Appeal Decision

Appeal Ref: APP/R5510/D/25/3359587

43 The Avenue, Ickenham, Hillingdon UB10 8NR

SCALE@A3: 1:100 | DRAWING No: TA-R00-PR-105

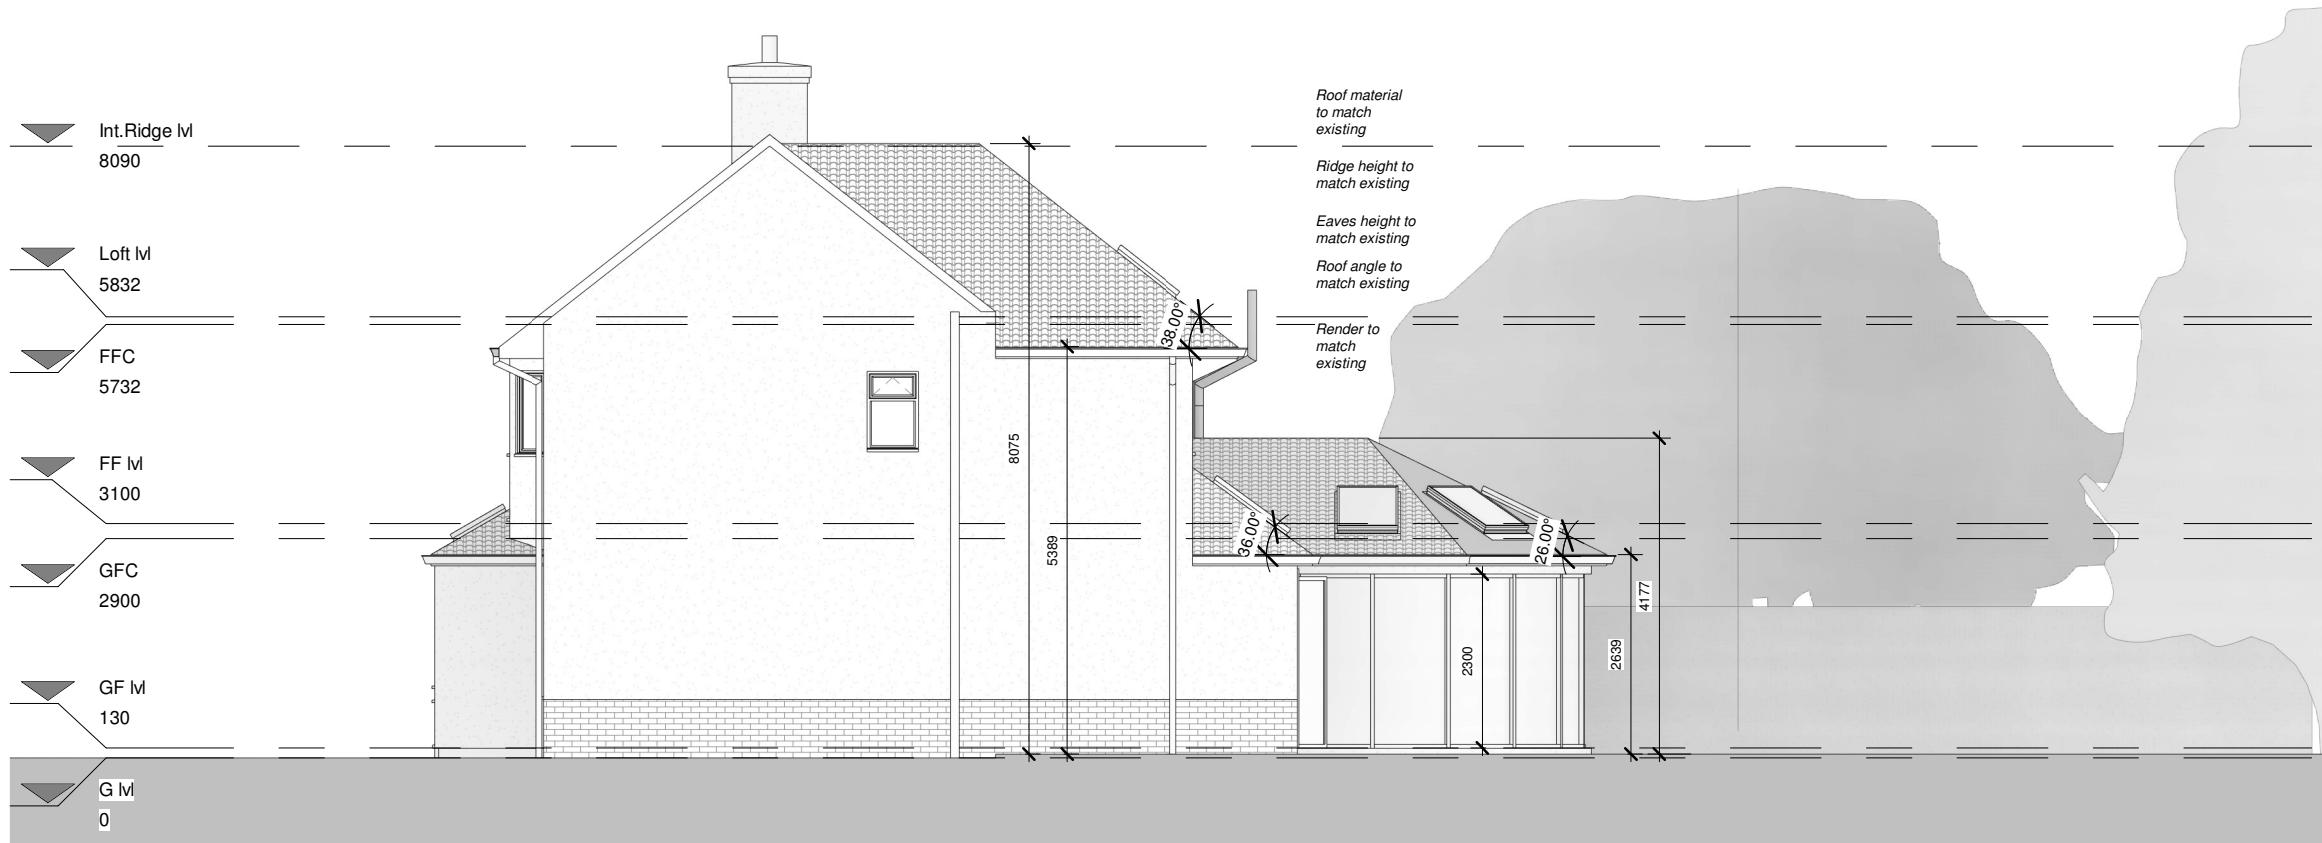
9. Given the existing building's asymmetric roofs, the scheme's largely hipped roofs would not appear incongruous, or result in an overly complex or imbalanced form; and, as noted by the Council, there are crown roofs in the surrounding area. Whilst the rear ground and first floor extensions would add significant bulk, in the context of the diverse form and proportions of other buildings in The Avenue, they would not appear out of place. The resultant building would continue to sit on a very spacious plot, and its rear face would be screened from many public vantage points by garages and flats to the south, and by trees.

TA-R00-PR-106

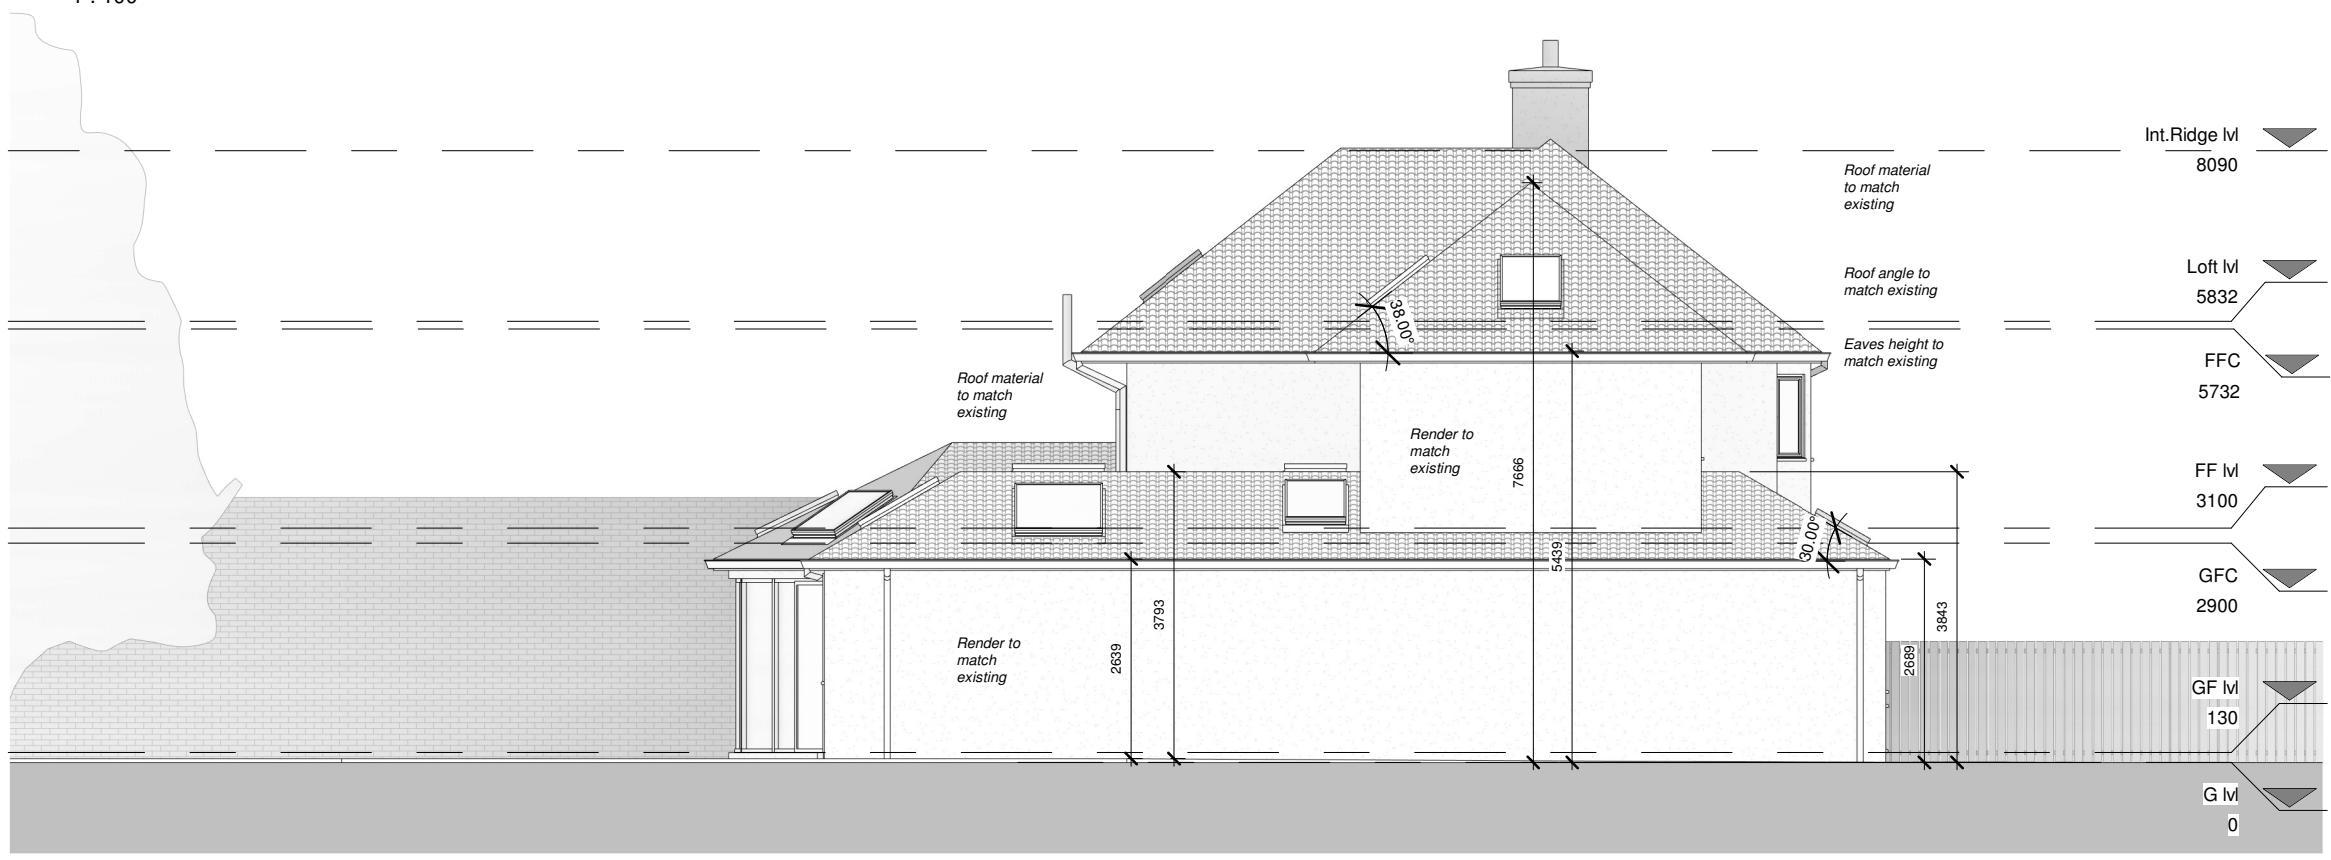
7. The proposed side extension would be fairly narrow and set well down from the host's ridge; and its first floor would be set well back from its front face and set in around 1 metre from the plot boundary. Thus, although it would link to an extended porch, and it would re-enforce the building's horizontal emphasis, it would achieve a subordinate appearance in the streetscene, and a degree of articulation which would help to break up the building's mass.

8. The windows to serve bedrooms 2 and 4 would be deeper than the others on its front face, but that slightly awkward appearance would be off-set by the replacement of the rather stark garage door with a matching bay window.
